2. **Project# 1010551**
15DRB-70434 EPC APPROVED SDP
FOR BUILD PERMIT

DATE: November 27, 2015
TO: Jack Cloud, DRB Chair
FROM: Catalina Lehner, Senior Planner *CL*
RE: Project #1010551, Sage Mobile Home Park
As-Built Site Development Plan for Building Permit

Staff met with the agent, Matt Myers, on November 16, 2015 to discuss how the Conditions of Approval are being met. Staff reviewed an updated version (v.3) of the site development plan for building permit and offers the following comments for clarification:

SHEET 1 of 8
S-1

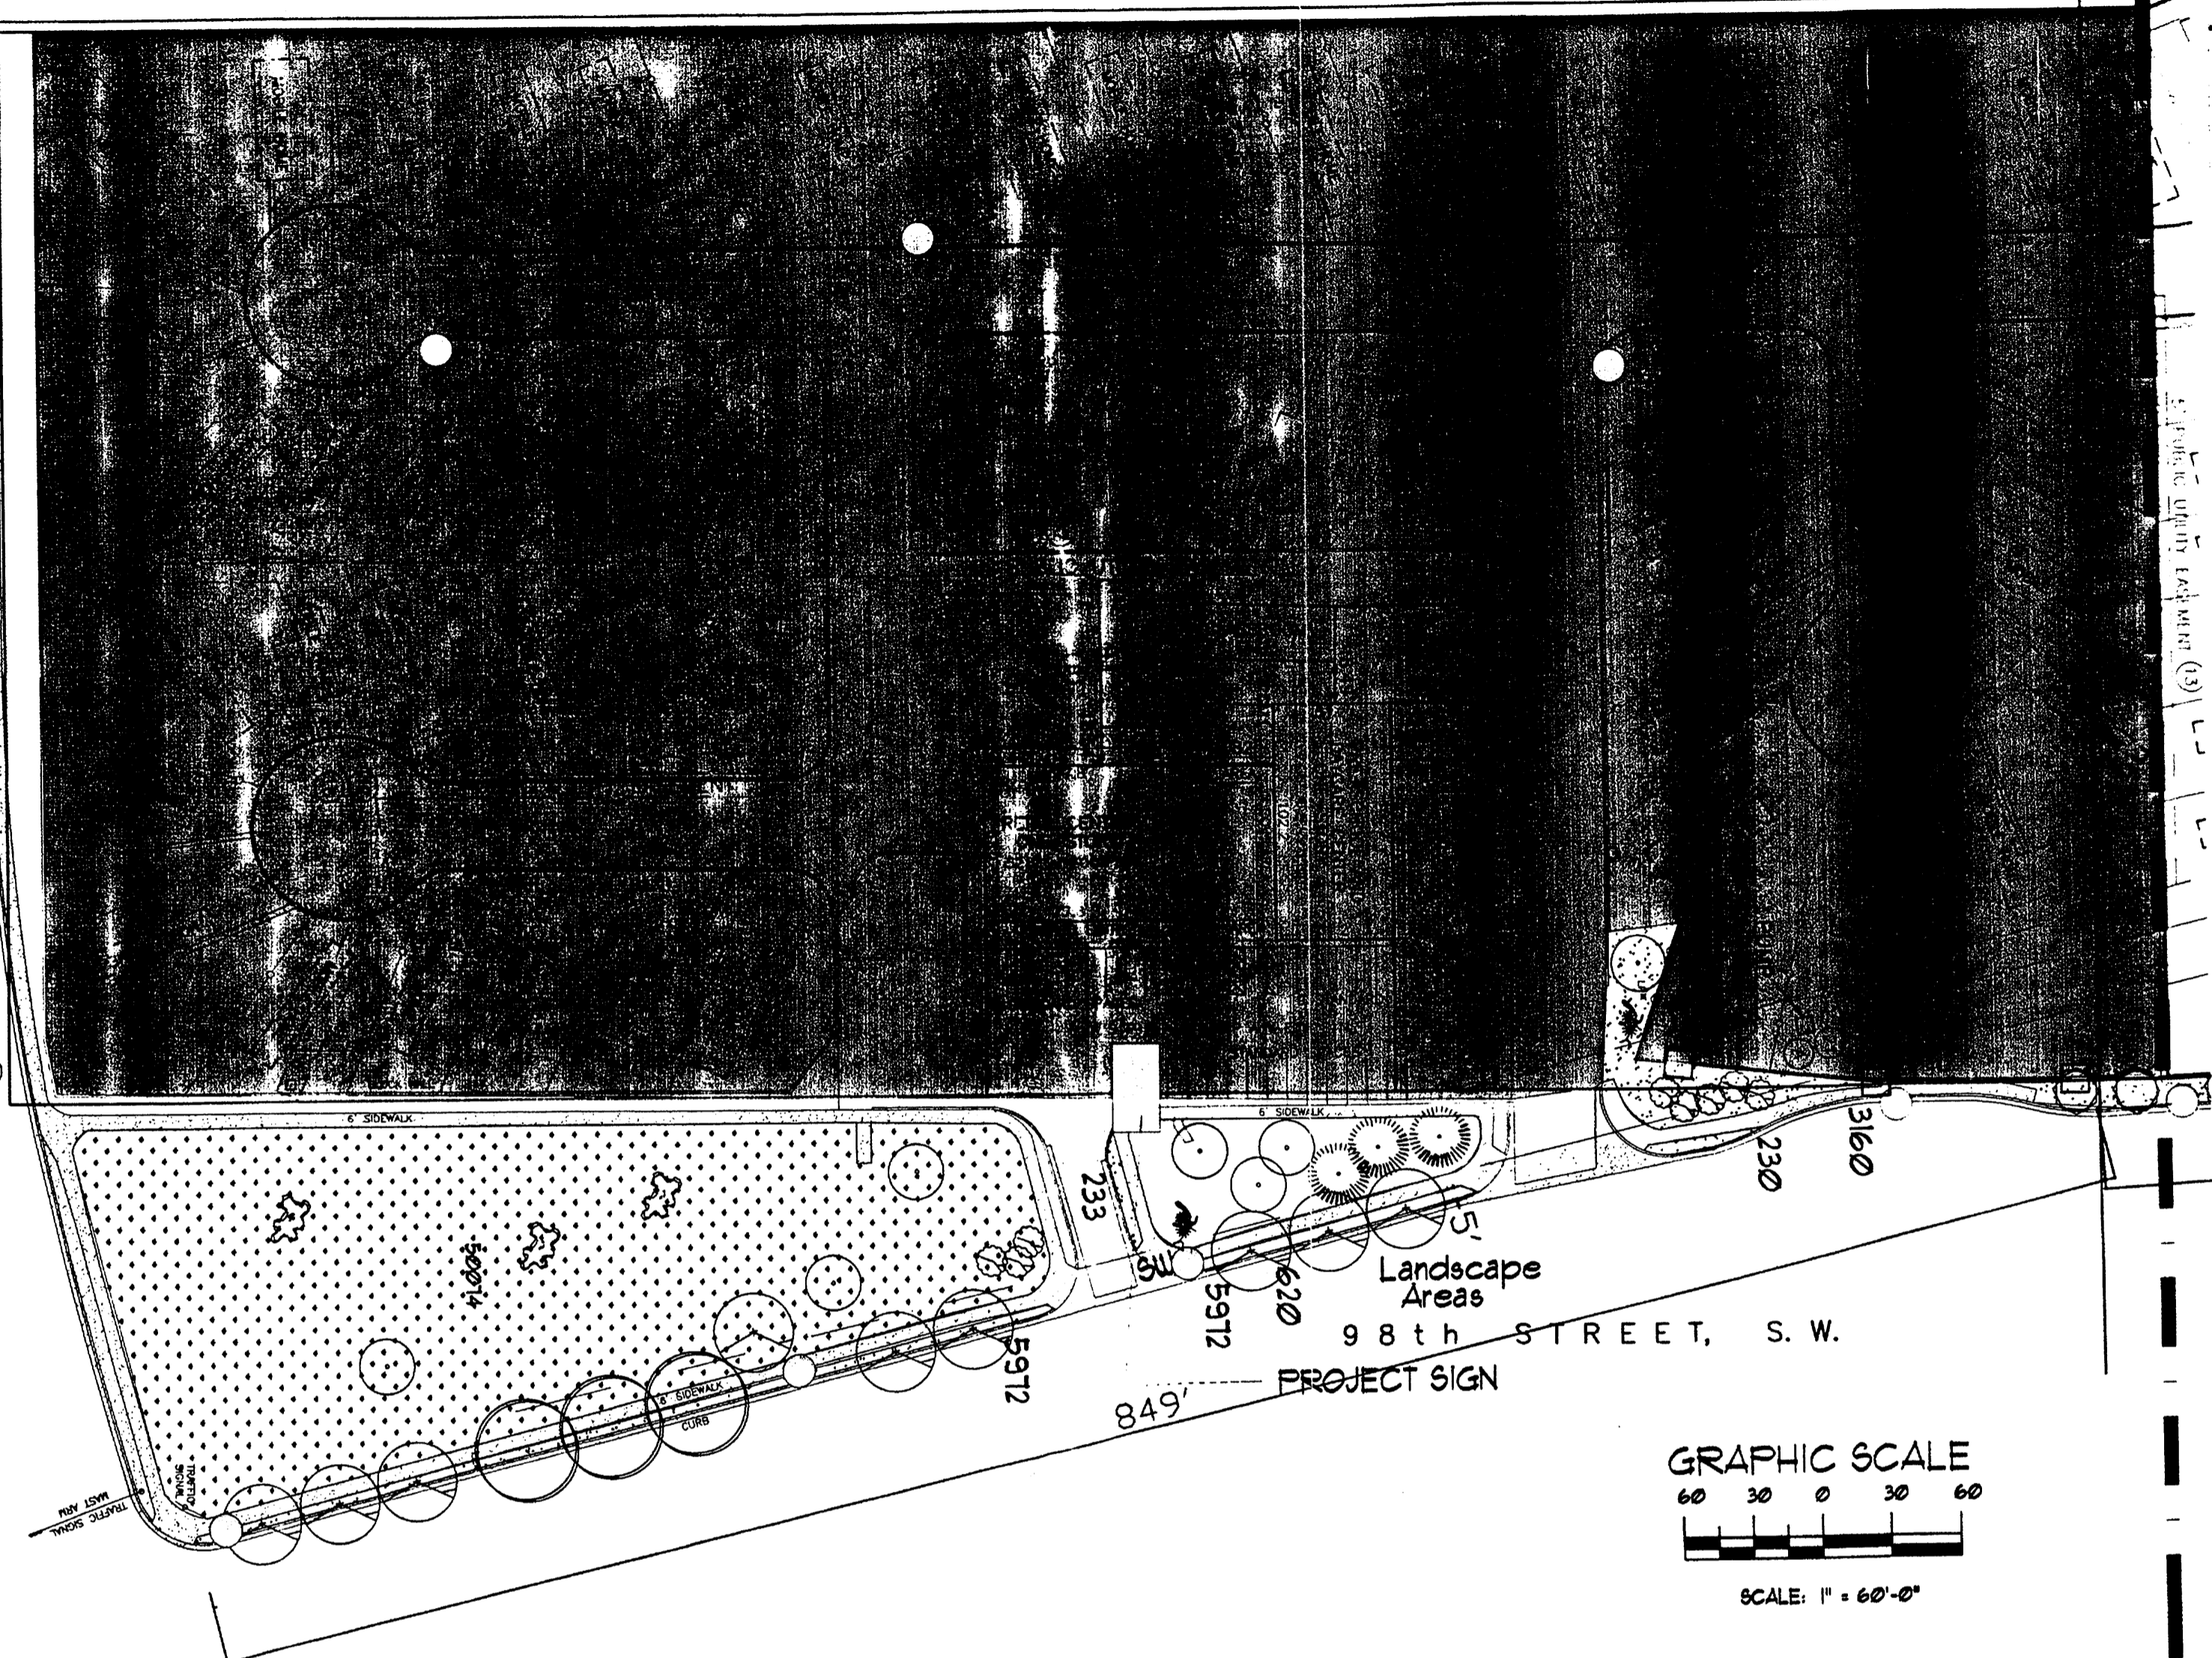
The copy of the site development plan that I reviewed copied very dark. The figures on Sheet 1 and Sheet 2, especially the picture of the existing trees, are not readable. Staff suggests lightening the copy and ensuring that the lightened copies become the file copies. This is also important because the file copies will be scanned in the future.

The existing sign on the southern portion of the property was labeled as requested. However, please clarify where the arrow is supposed to point.

S-2

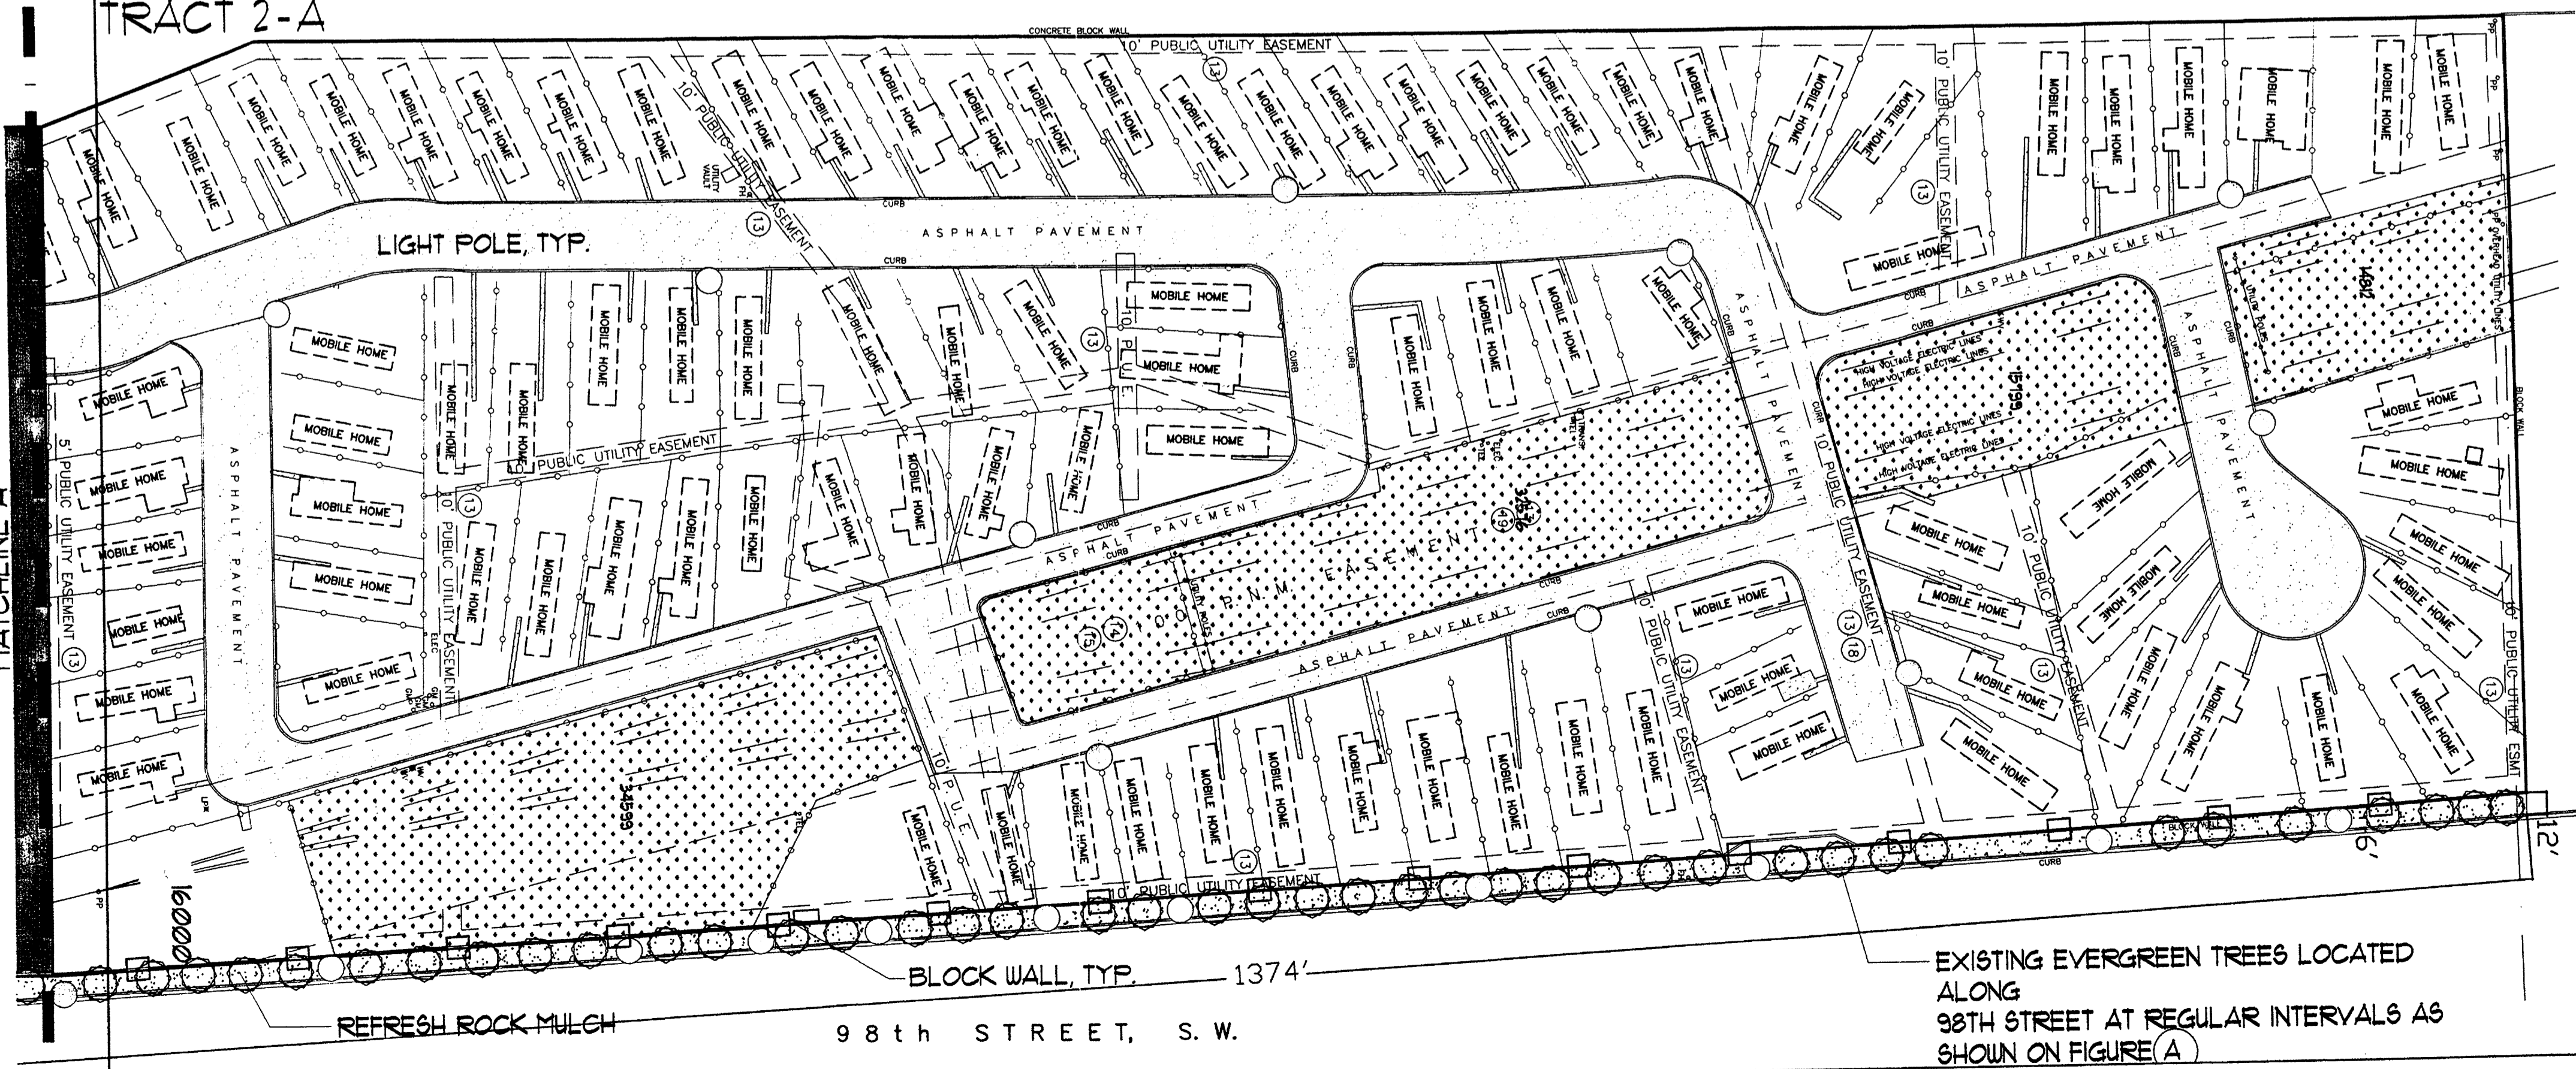
Please label the plain circle symbol as "existing light pole". Otherwise, this symbol looks like a type of tree or plant that's supposed to be on the landscaping legend but isn't.

Please make it clear that the intention is for existing trees to remain, unless determined that they're sickly. Otherwise, they will not be replaced.
